WOODMEN HILLS METROPOLITAN DISTRICT
 REGIONAL WATER RECLAMATION FACILITY

LANDSCAPE PLAN

Project No.:	112.88
Scale:	AS NOTED
Date:	05/22/17
Design:	RMM
Drawn:	RMM
Check:	JPM
Revised:

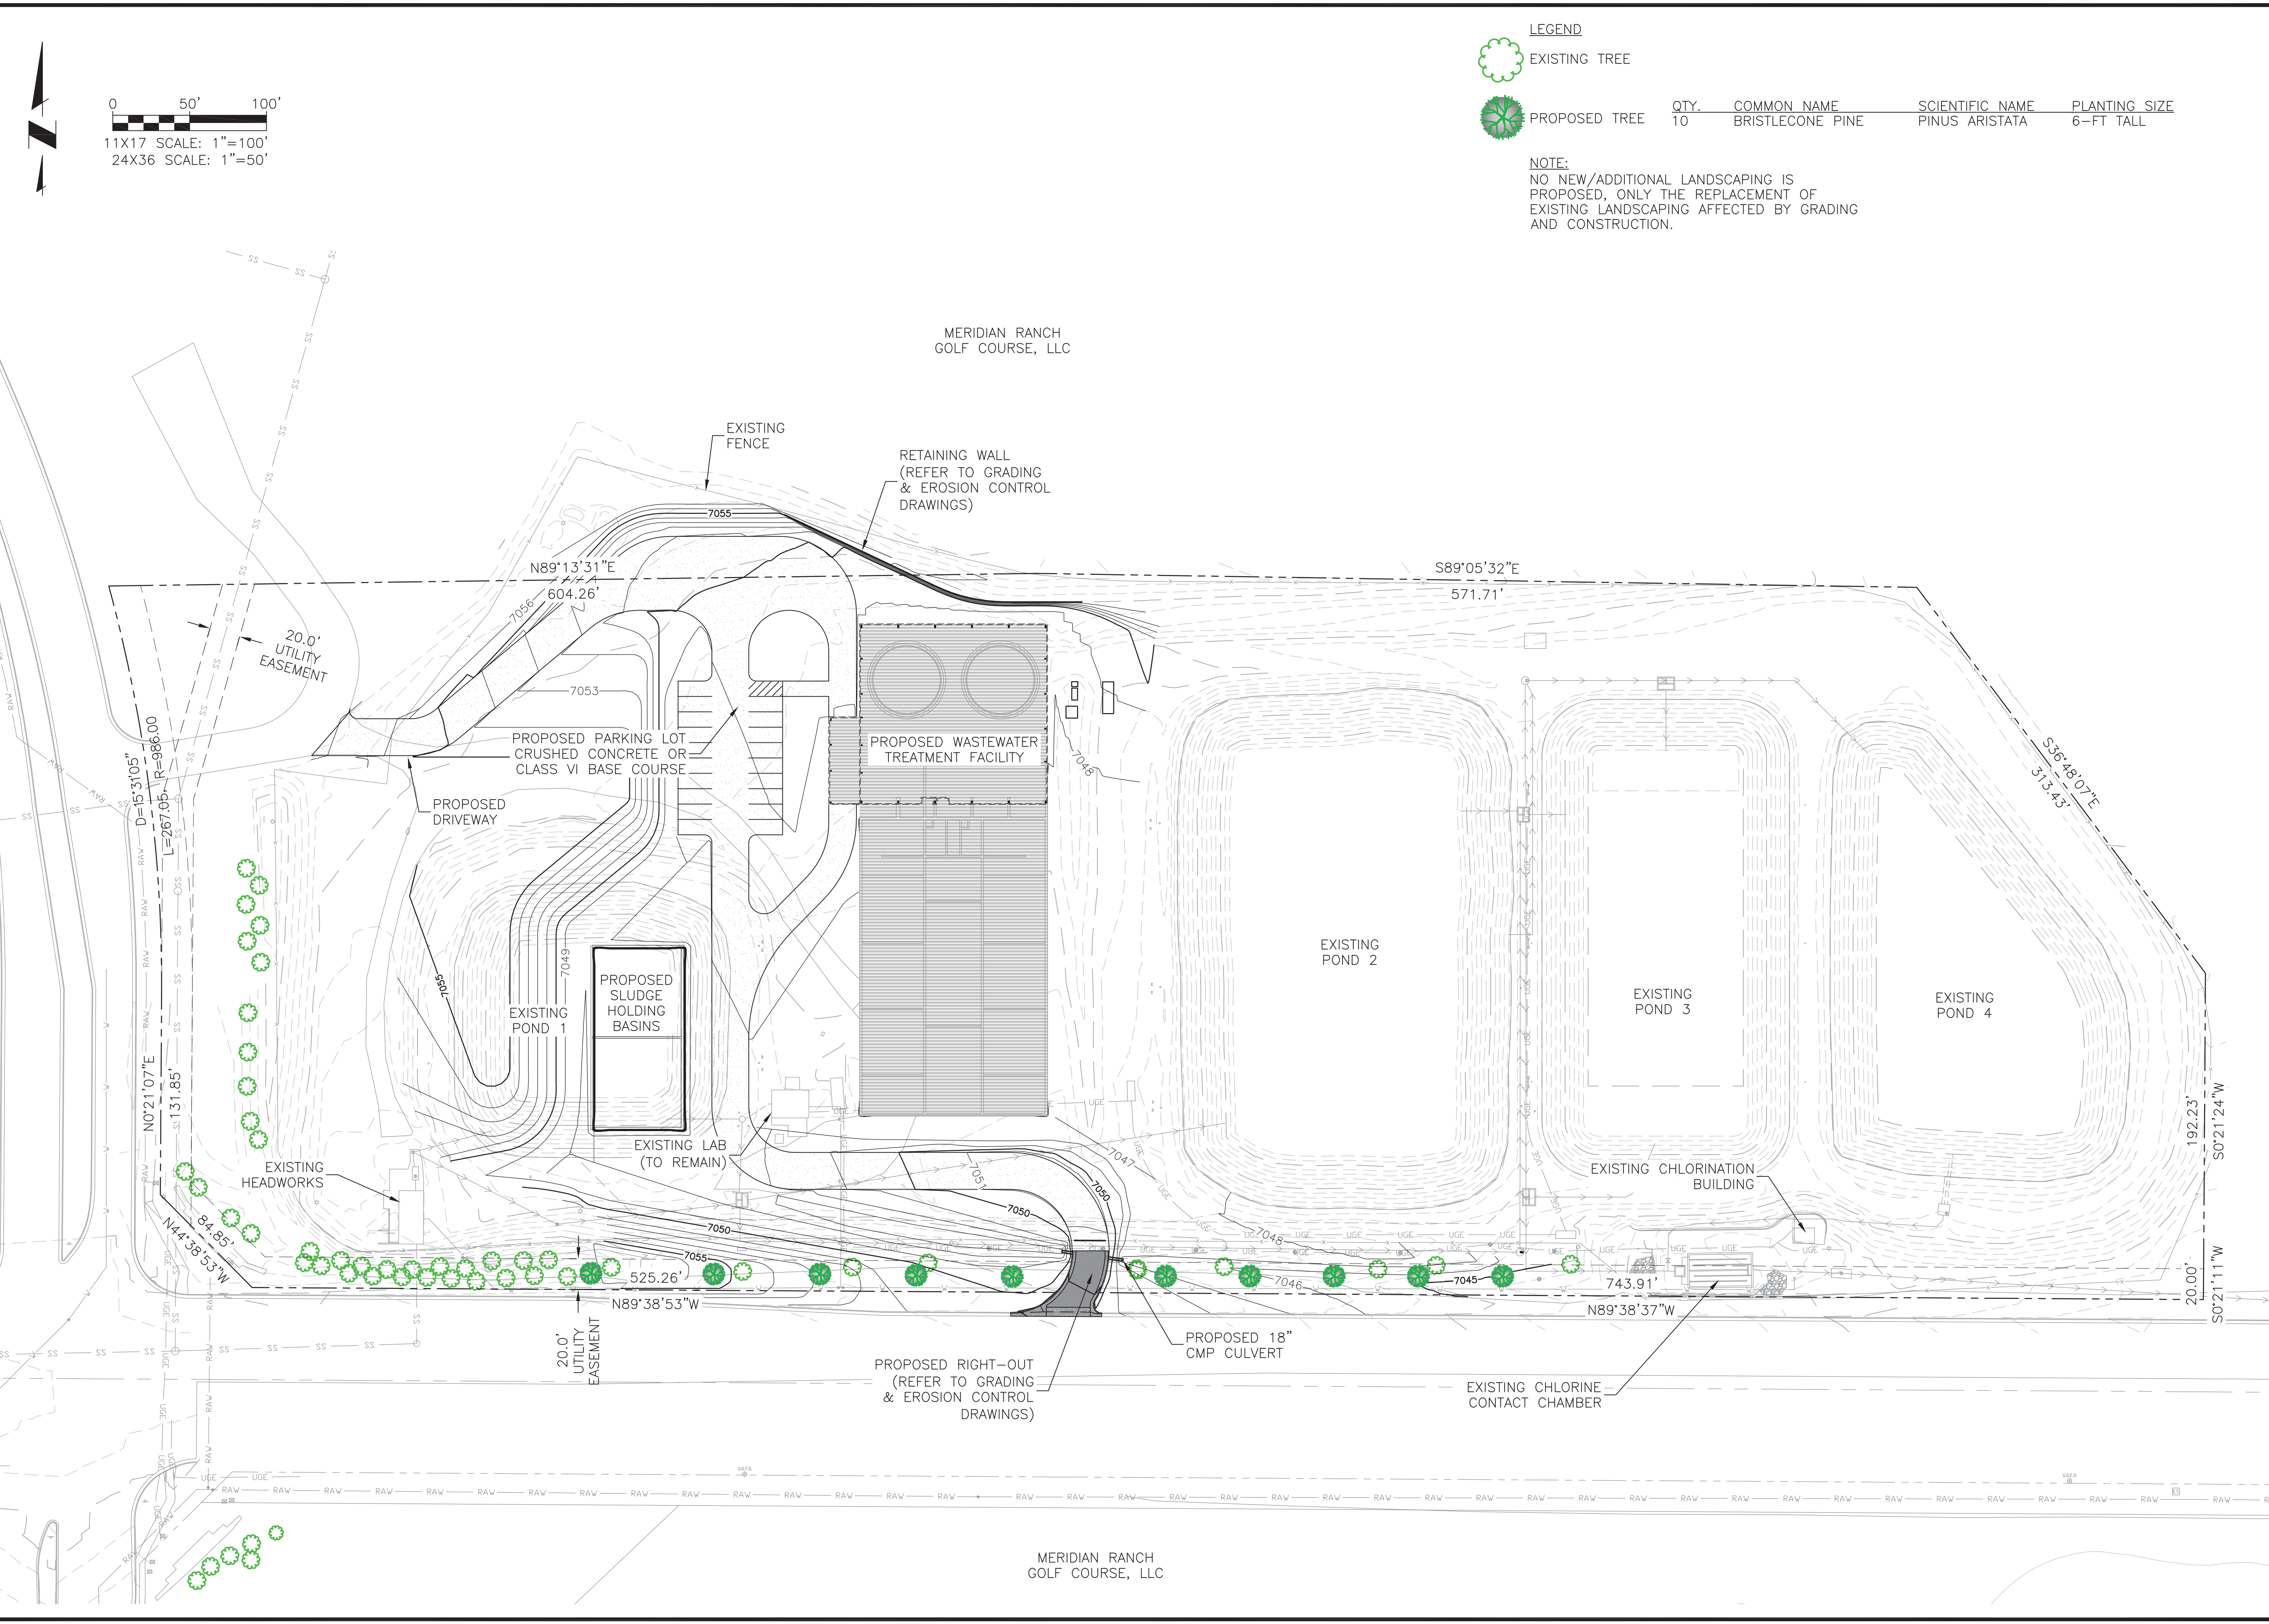
add property line and include all existing landscaping.

These are existing. Per the letter of intent you are not adding any landscaping. Please revise.
